Re: Albuquerque Biopark Australian Exhibit Phase II Grading and Drainage Plan

Engineer's Stamp dated 7-11-10 (K13/D044)

Re: Albuquerque Biopark Australian Exhibit Phase II Grading and Drainage Plan

Engineer's Stamp dated 7-1-10 (K13/D044)

AUSTRALIAN EXHIBIT, PHASE II
PROPOSED GRADING PLAN

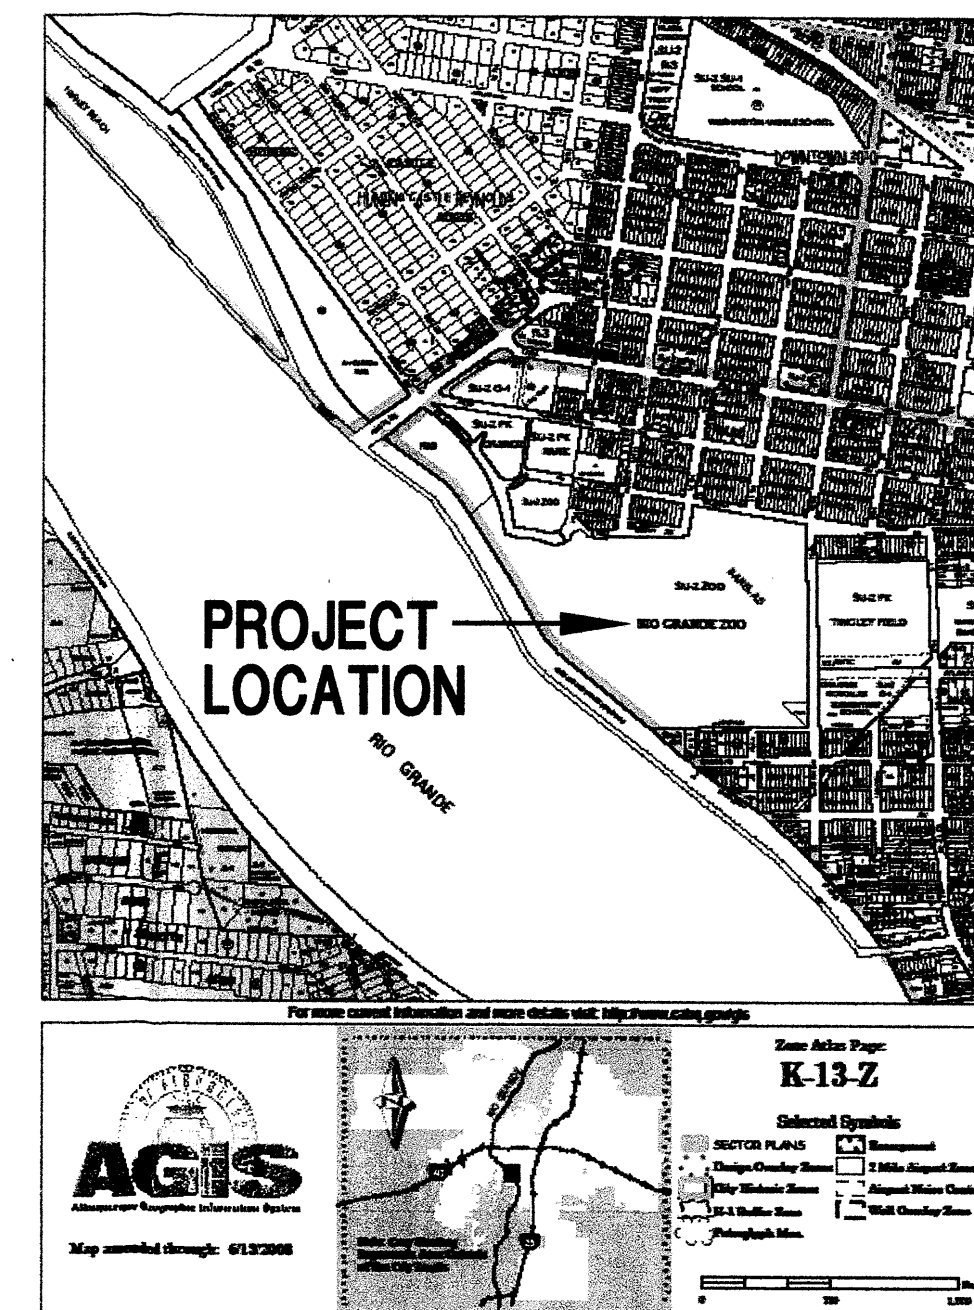
- Provide the Finished Floor elevation(s) for the proposed building.
- Provide the Required Volume and the Provided Volume for the retention ponds.
- It appears the volume calculations are for the 6-hour storm. Retention ponds are required to contain the 10-day volume.

- Finish floor elevations are shown. The building is a multi-level building for public viewing of the crocodiles. The various finish floor elevations are shown on the proposed grading plan.
- Required pond volumes and water surface elevations are shown for the 100-Year, 10-Day storm event.
